# CITY OF ALBUQUERQUE

**Re: MAS Charter School  
Neighborhood Impact Assessment, HT#L16D037**  
Report dated April 2022  
Engineer's Stamp -----

The subject Neighborhood Impact Assessment (NIA) received April 5, 2022, has been reviewed by the City of Albuquerque Planning Development Transportation Section. The City had project meeting on May 6, 2022 to discuss the NIA and potential improvements. The City has the following comments that should be addressed in the next submittal.

Figure 1. Site Plan

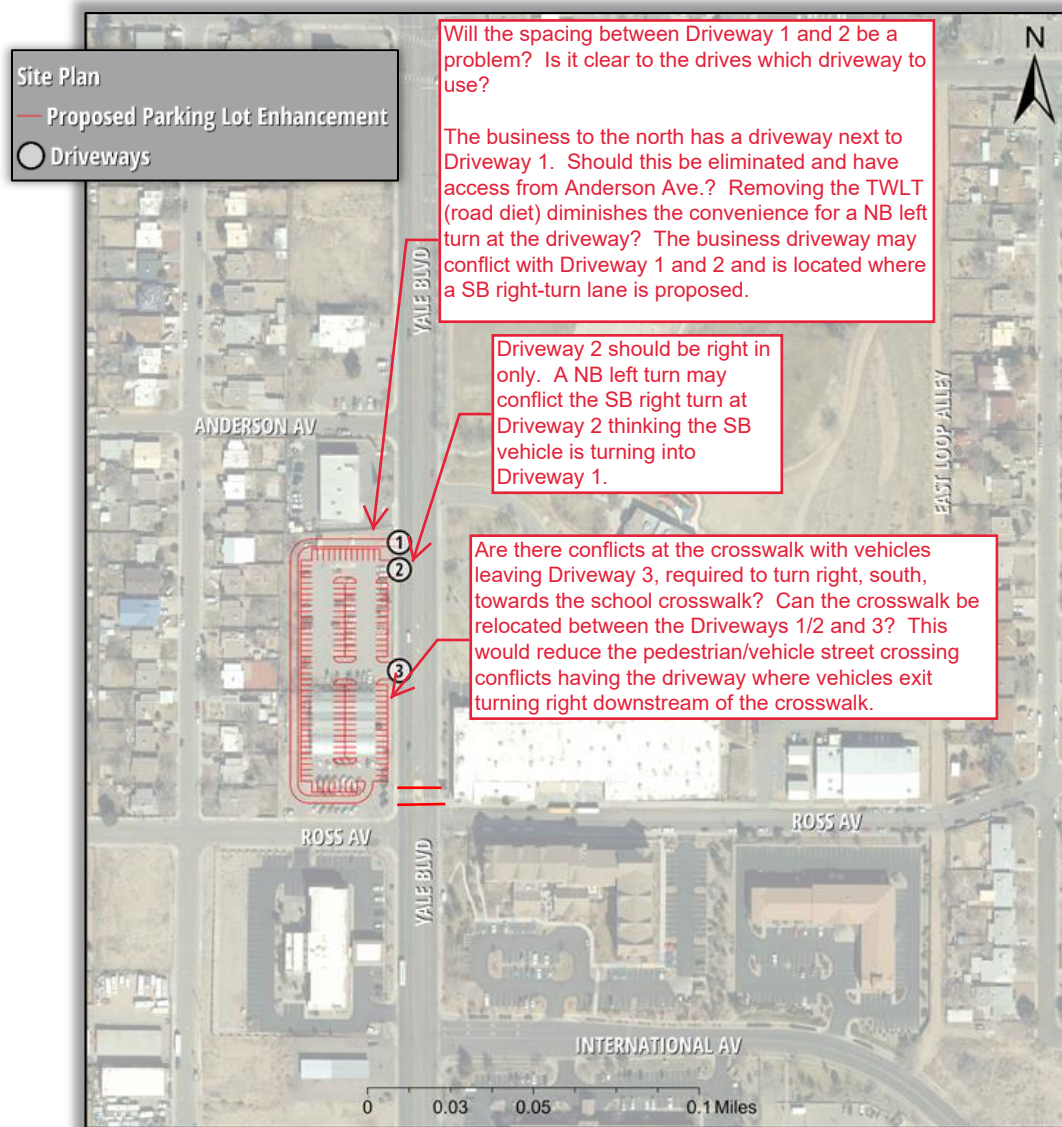
- The traffic analysis should be reevaluated excluding the use of the East Alley loop.
- Will the spacing between Driveway 1 and 2 be a problem? Is it clear to the drives which driveway to use? Are these areas in the proposed parking lot segregated? Is it possible to correct after entering the wrong driveway; drivers that wish to park can access the parking area or vehicle dropping off can access the queue?

- Driveway 2 should be right in only. A NB left turn may conflict the SB right turn at Driveway 2 thinking the SB vehicle is turning into Driveway 1.
  - Provide a discussion on the conflict points for Driveway #1 and #2 including the business access immediately north of Driveway #1.

- Show the location of the School Bus drop-off/pick-up location. Provide an estimated maximum storage required and show that on the site plan.
- Ross Ave. is proposed as a Bike route, was this considered in the NIA?

Figure 9: South Loop Build-out Traffic Volumes

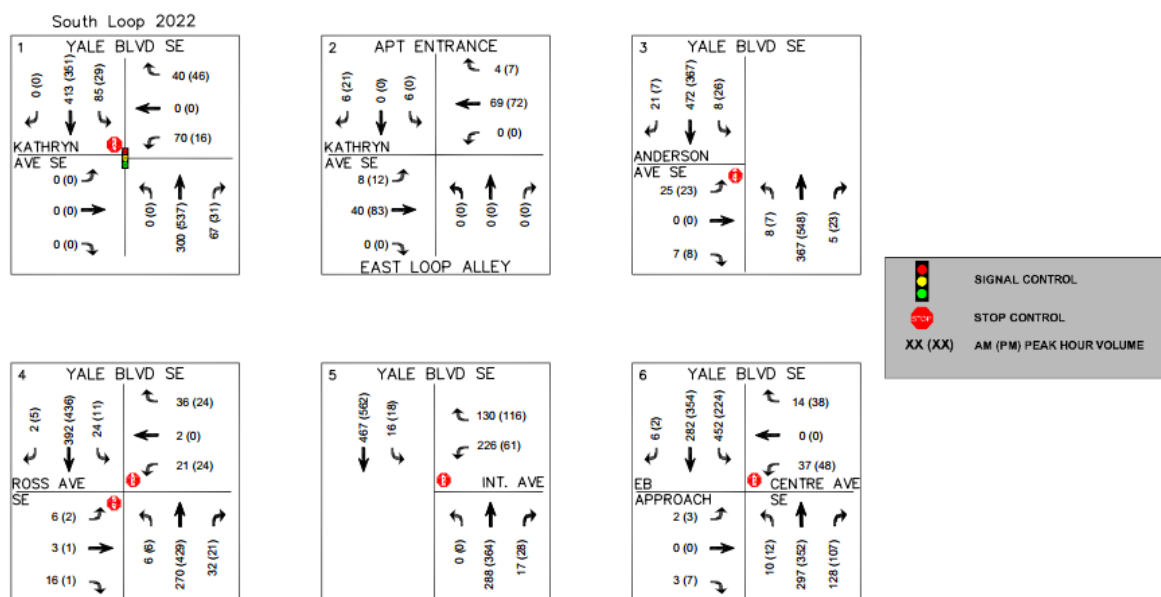
- Table 24: Queuing Analysis, South Loop Build-out; Label the columns. The available queue storage is deficient (1460' max required, 1400' available) The sentence following Table 24 says the storage is a sufficient, is that correct?
- Provide mitigation of the failing movement at signalized intersection of Yale Blvd. and Kathryn Ave.
